BENGALLA MINE CONTINUATION PROJECT - MODIFICATION 1 STATEMENT OF ENVIRONMENTAL EFFECTS

GHD have been engaged to prepare a submission on the Bengalla Mine Continuation Project – Modification 1 Statement of Environmental Effects (SEE) on behalf of Muswellbrook Shire Council (MSC)

This report outlines the review of the SEE identifying key issues, information or assessment gaps and any other aspects which may impact on MSC's operations and the LGA.

Approved Overview - Year 4 Mine Plan

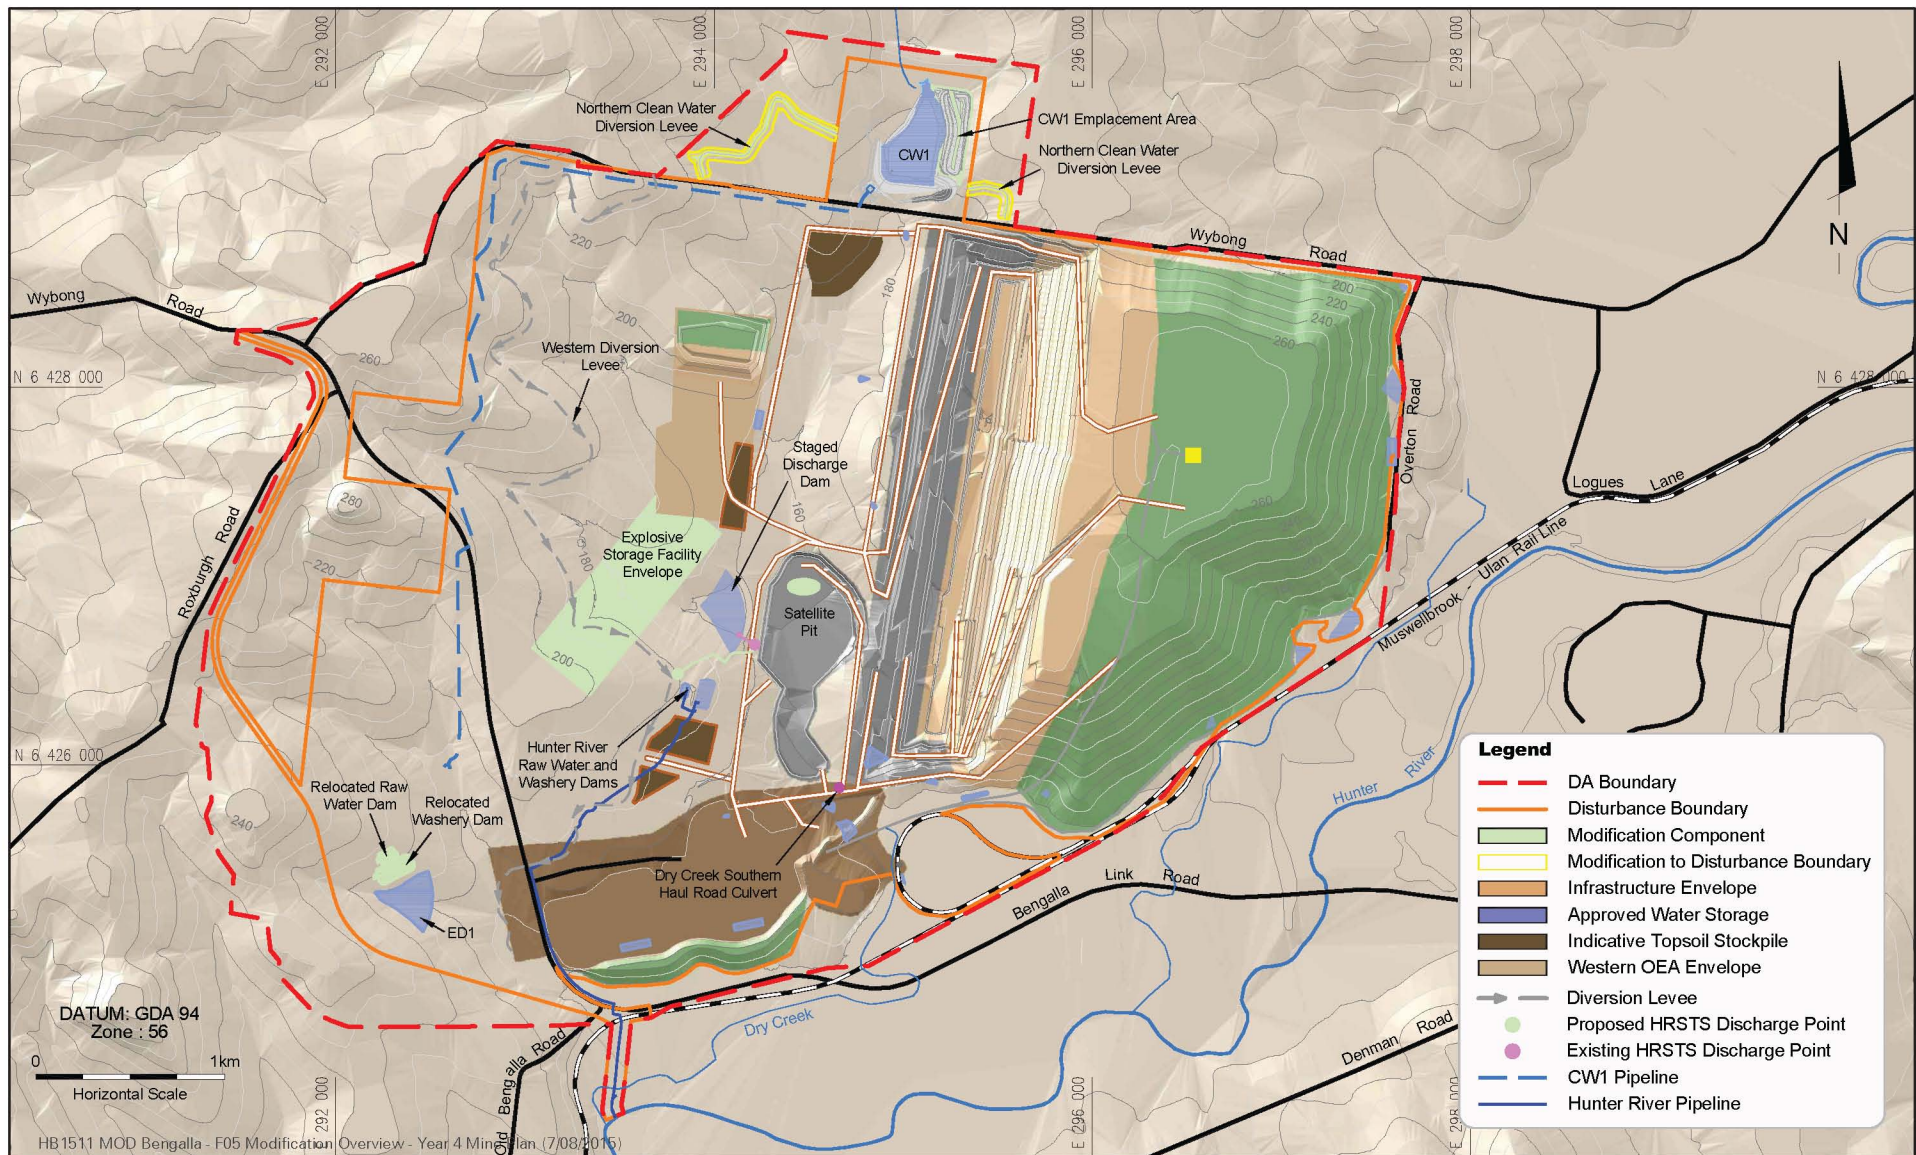
- Satellite Pit Diversion Dam is shown on Figure 4 of the SEE (Year 4 Approved Mine Plan) but does not show in Figure 5 (Year 4 Modified Mine Plan).
- Construction of Clean Water dam (CW1) at a located north of Wybong Road with pumping of water from CW1 to Dry Creek– shown on Figure 4 (Year 4 Approved Mine Plan).

- Staged Discharge Dam – shown on the Figure 4 (Year 4 – Approved Mine Plan) and retained on Figure 5. Figure 5 makes no reference to relocation of the discharge release point.

The explosives storage facility is shown on Figure 4 of the SEE (Year 4 – Approved Mine Plan) as being located on the existing OEA in a fully bunded area.

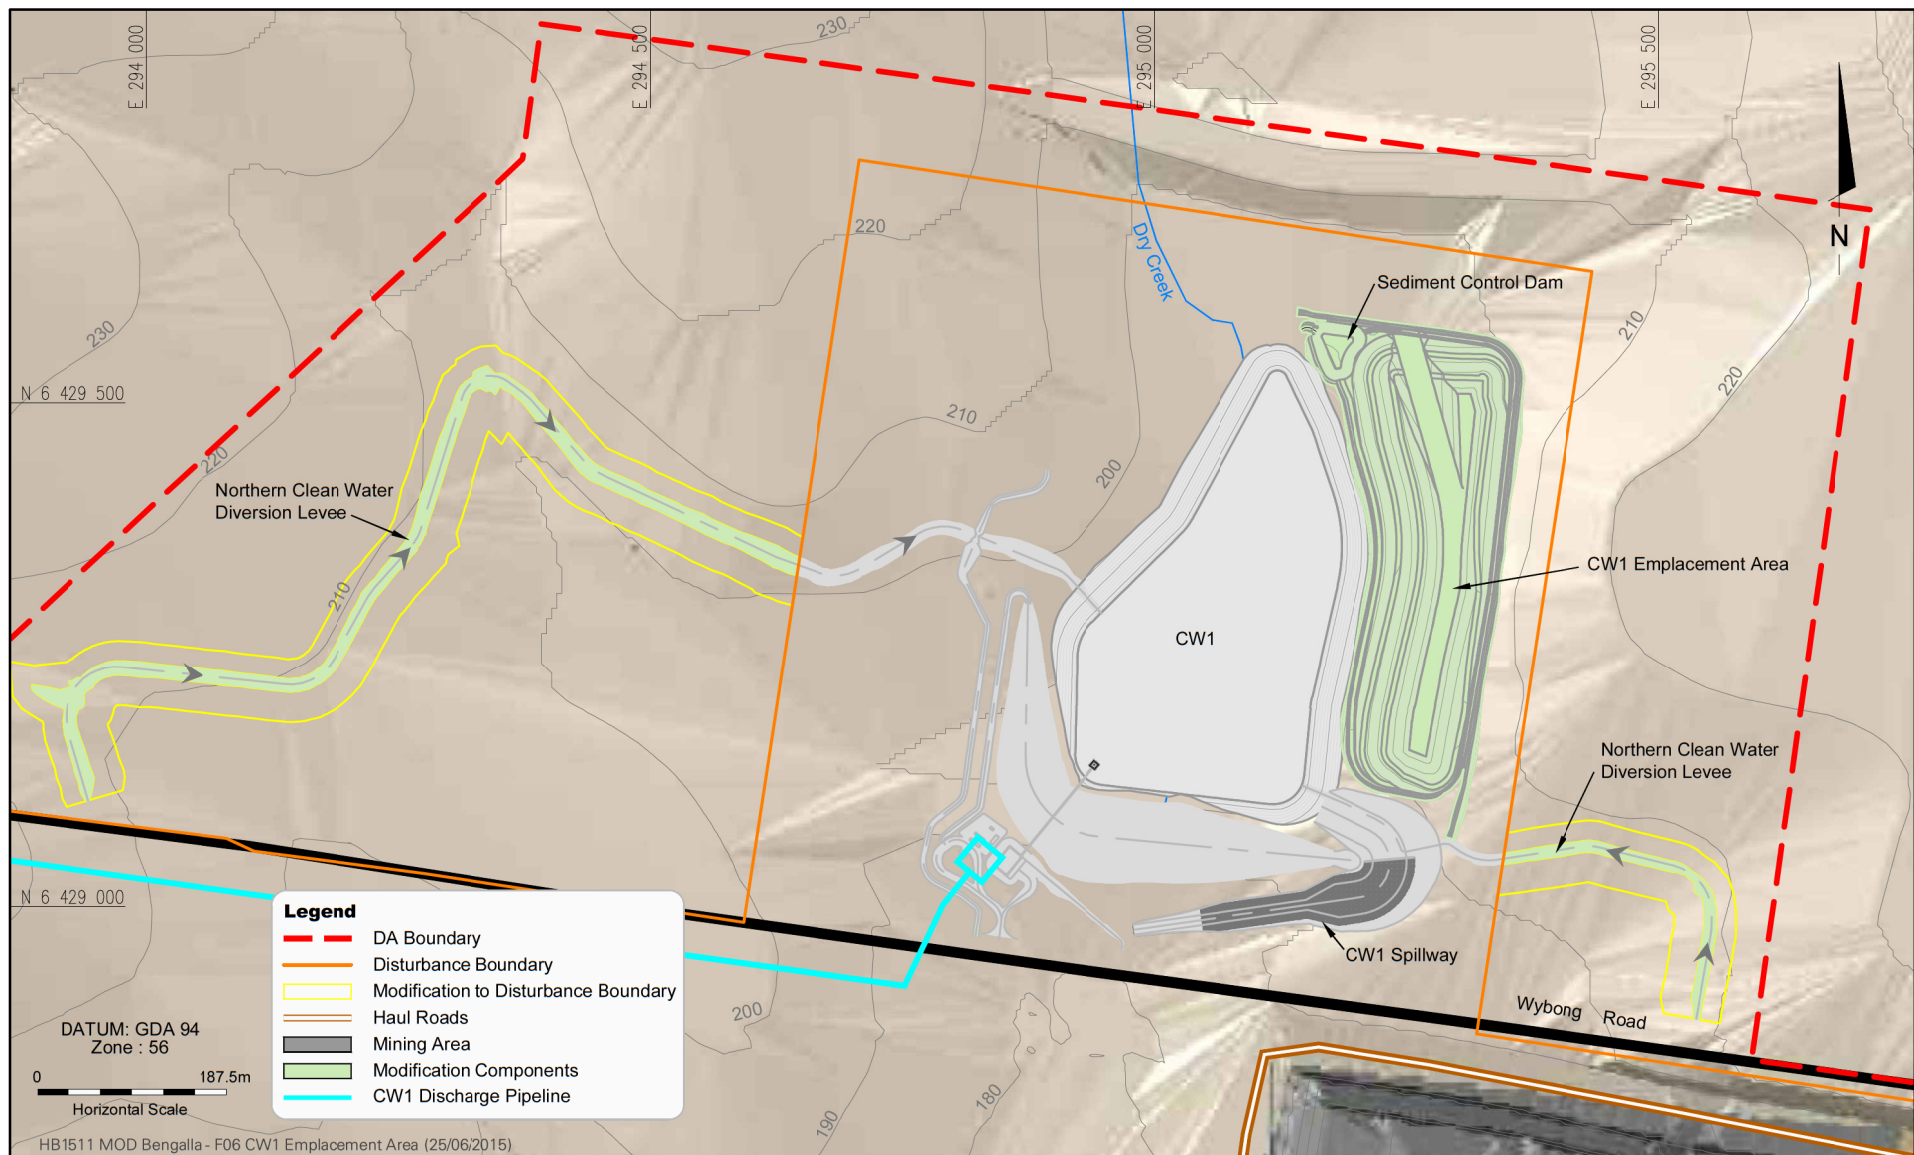
An indicative location of the proposed HRSTS discharge point is shown on Figure 5.

Figure 5 of the SEE indicates the Raw Water Dam and Washery Dam will be relocated to positions adjacent to ED1 and the SEE text indicates the relocation will be required by around 2019. By reference to Appendix D of the EA it would appear that ED1 is an approved storage that will eventually replace the Staged Discharge Dam.

Figure 6 of the SEE provides a diagrammatic representation of the proposed CW1 Emplacement Area which is shown as being within the approved disturbance boundary. The proposed Emplacement Area is shown immediately east of CW1. Associated text within the SEE indicates the maximum batter slope for the emplacement will be 1V:2H.

Figure 6 appears to show a clean water diversion levee around the emplacement.

- The batter slopes are indicated as being up to 1V : 2H. Council is concerned about the practicality of stabilisation of this batter. A sediment control dam is shown for the Emplacement Area but the functioning of the overall emplacement stabilisation is not considered to be clearly articulated.
- Temporary erosion control measures have been described in the SEE as being implemented and maintained until the materials are relocated. The SEE provides no information on the likely life of the emplacement and thus Council is concerned about the maintenance of this area.
- Any sediment, should it enter CW1 and remain in suspension, would be pumped through the discharge pipeline prior to discharge to Dry Creek downstream of any LDP.

Council does notes that part of this envelope is located upslope of the Western Diversion Levee which is a clean water diversion levee. As such, should the facility be located to the west of the Western Diversion Levee then appropriate erosion control measures should be implemented and maintained for the life of the facility to provide sediment and erosion protection for any disturbed area in the clean water catchment for the Western Diversion levee.

Council does not consider this aspect of the proposed modification should be approved. Should the Department grant this aspect of the approved modification then Council is of the opinion that stringent requirements should be imposed on the implementation and maintenance of the constructed erosion control works for this modified emplacement.
